From: Andre Vernez <Andre.Vernez@shoalhaven.nsw.gov.au>
Sent: Tuesday, 31 January 2017 11:18 AM
To: Deana Burn
Subject: Shoalhaven Starches Modification 12 - Ethanol Distillery - COMMENTS FROM SHOALHAVEN CITY COUNCIL
Attachments: SW DA Notice - 3A07 1008 - N5 (MOD 12).pdf

MODIFICATION NO. 12

J	31/10/16	D3	Wording.	P.C.B.H.
H	27/10/16	ALL	Entrance relocated.	P.C.B.H.
F	20/9/16	ALL	Rail sidings added.	P.C.B.H.
E	15/9/16	ALL	Car parks relocated.	P.C.B.H.
1	16/8/16	ALL	Draft	P.C.B.H.
ISS	DATE	ZONE	CHANGE	AMENDMENTS BY CKD

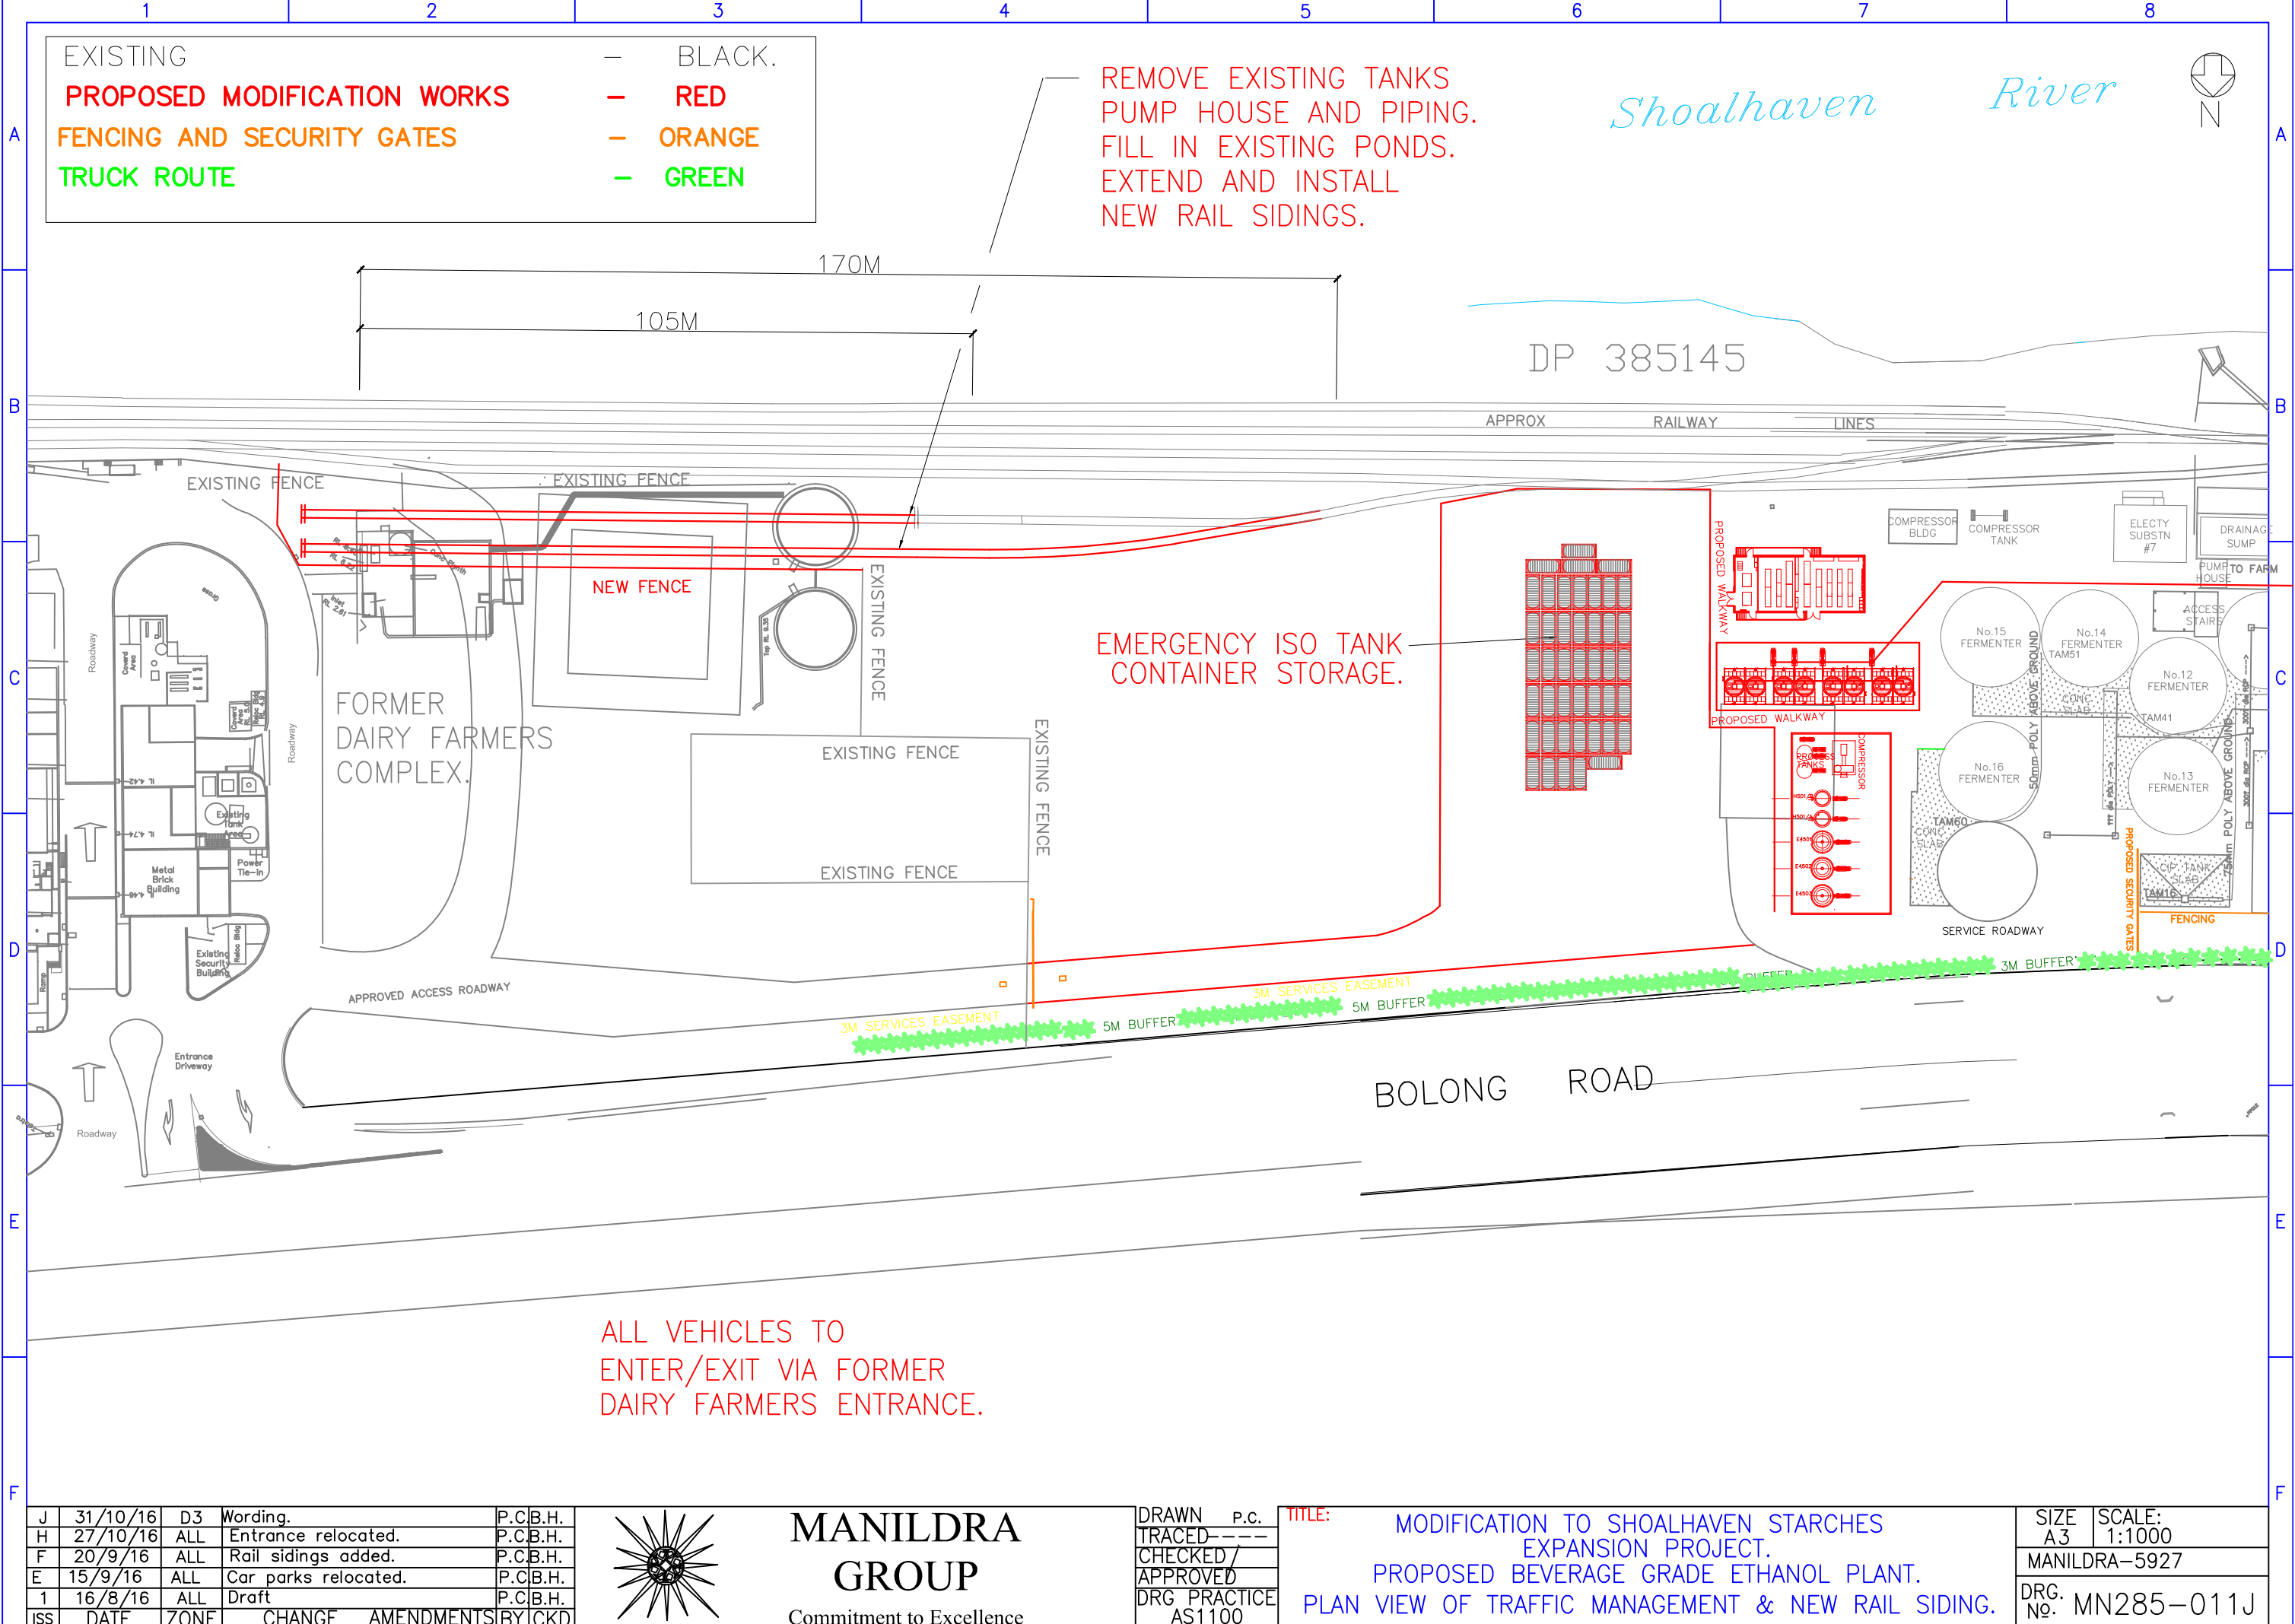
The current proposal includes the redevelopment of the existing car parking in the vicinity of the BOC site. It makes mention of laying of additional pavement to provide for additional parking, however, clarification should be sought on the pavement type and extent.

The plan for the car park at the BOC site is shown on page 19 of the TIA (Drawing No. MN285-002J). It does not adequately detail the driveway location and width, the parking space and circulating aisle dimensions, whether the hard stand area is to be sealed, the extent and type of any additional road pavement and whether the spaces are to be line-marked.

The existing car parking spaces are unmarked and the current road surface is unsuitable for line marking of spaces. Where informal, unmarked parking is provided, the capacity of car parking areas is reduced compared to spaces that are able to be marked.

The plan for the new parking does not provide sufficient details in regards to vehicle swept paths to ensure turning movements may be undertaken safely and efficiently.

Confirmation is also required, via vehicle swept path analysis, that access to the existing fire pump house by fire appliances and other service vehicles will be maintained in order to provide access.

Details of any regulatory/warning signs to assist with maintaining access and sight distances in the vicinity of the pump house and within the car park should be shown on the plan.

The plan for the proposed car park at the BOC site shows a total of 83 (46+37) car spaces. This provides an apparent discrepancy of 23 spaces. The TIA does not identify whether the required 60 additional spaces that were to have been provided at the Dairy site, but are now intended to be located at the BOC site, will in fact all be provided for at the BOC site, or whether some have been absorbed into existing car parking spaces at the BOC site.

The existing car parking positioned along the southern boundary of the BOC site appears to be able to accommodate 20 cars, however, 23 cars are shown on the current plan. It is unclear what works are proposed to accommodate these extra vehicles.

Similarly, on the northern side of this car park there is currently space for approximately 12 vehicles, however, 14 vehicles are shown on the current plan.

The TIA does not specify how these additional 5 parking spaces are to be provided. It makes mention of “re-laying of additional pavement for parking purposes” [p18], however, the extent of the larger car park is not adequately documented on the current plan.

The plan indicates those spaces coloured in magenta are part of an “Original Mod 2 Approval”, however, these appear to be randomly positioned throughout the proposed car park.
